CITY OF ALBUQUERQUE

January 27, 2012

**Re: US New Mexico Federal Credit Union
Tract 5, Andalucia at La Luz
Conceptual Grading and Drainage Plan
Engineer's Stamp Date 1/04/2012 (E12/D015D1)**

Sheet
C-3

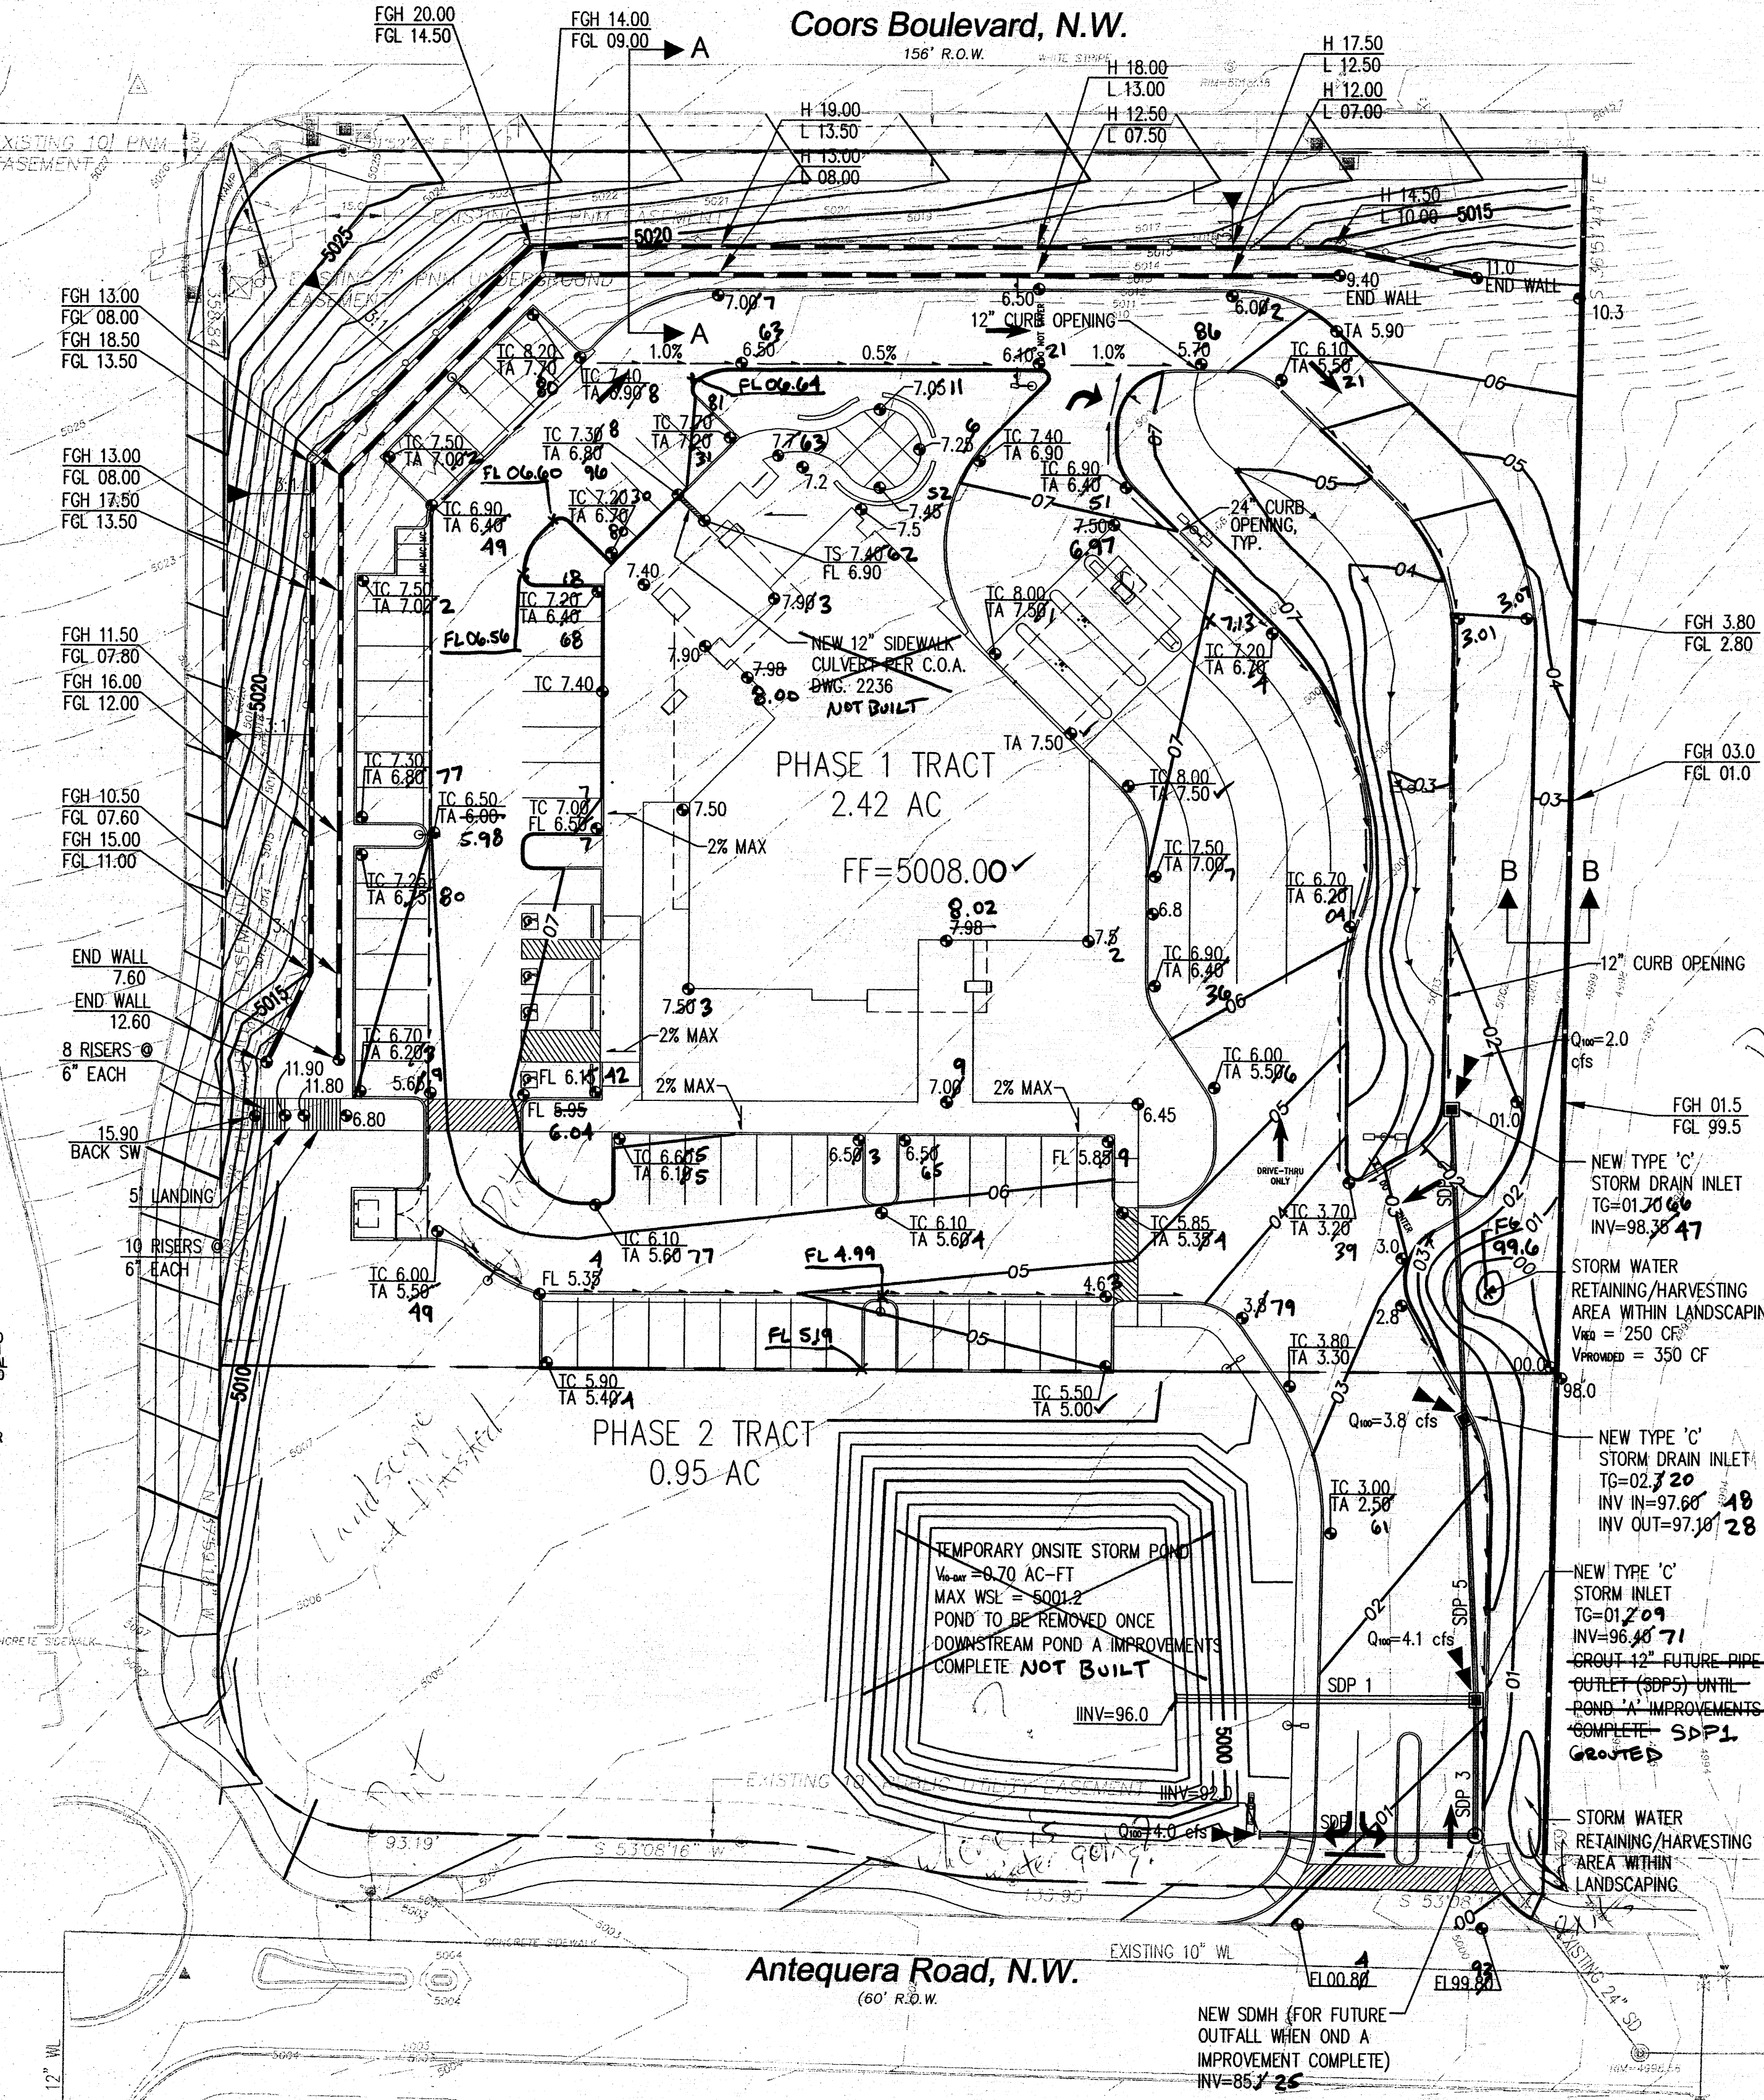
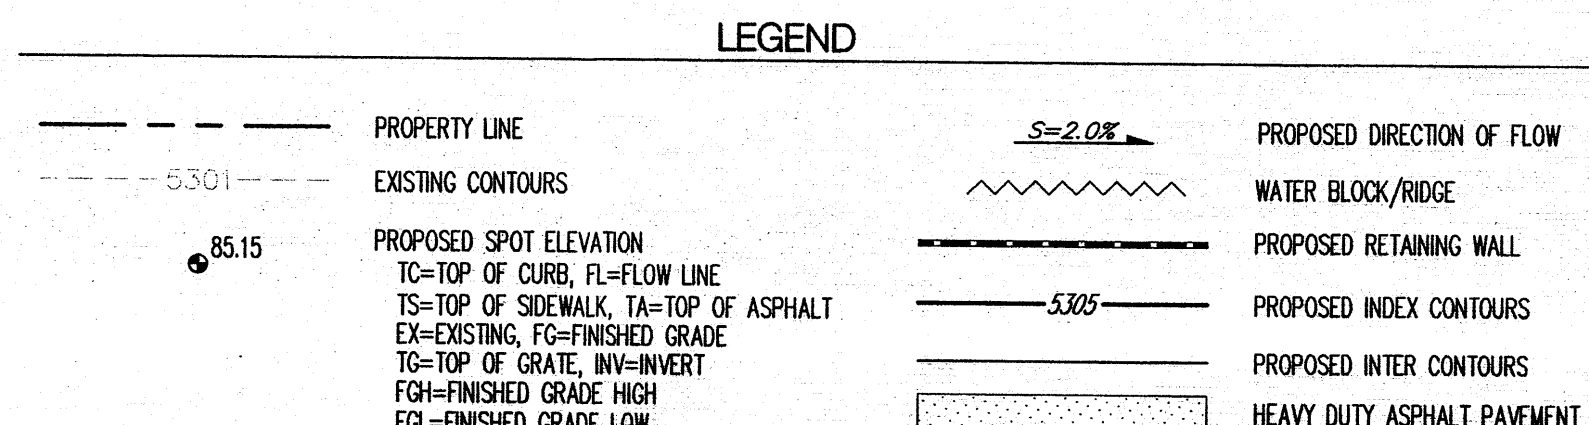
- Provide BM. The elevations should be based on NAVD 88.
- Add top of wall and top of footing for the retaining wall.
- Show additional spot elevations around the trash enclosure and handicap spaces.
- Inlet located at the southeast corner of the lot within the landscaping area is called out to be a Type C inlet and appears that it should be a Type D inlet. Does the inlet have to be 7.8' deep?
- The invert for storm pipe SD1 is 9' deep. It appear to be too close to the proposed sidewalk for future connection.
- Please provide as-builts and volume calculations for the existing retention pond located west of the Lower Corrales Riverside Drain (Pond A under the City Drainage Number E12/D015D). Please also confirm that Pond A will overflow to Pond B. Was water table taken into consideration when the retention ponds were designed?
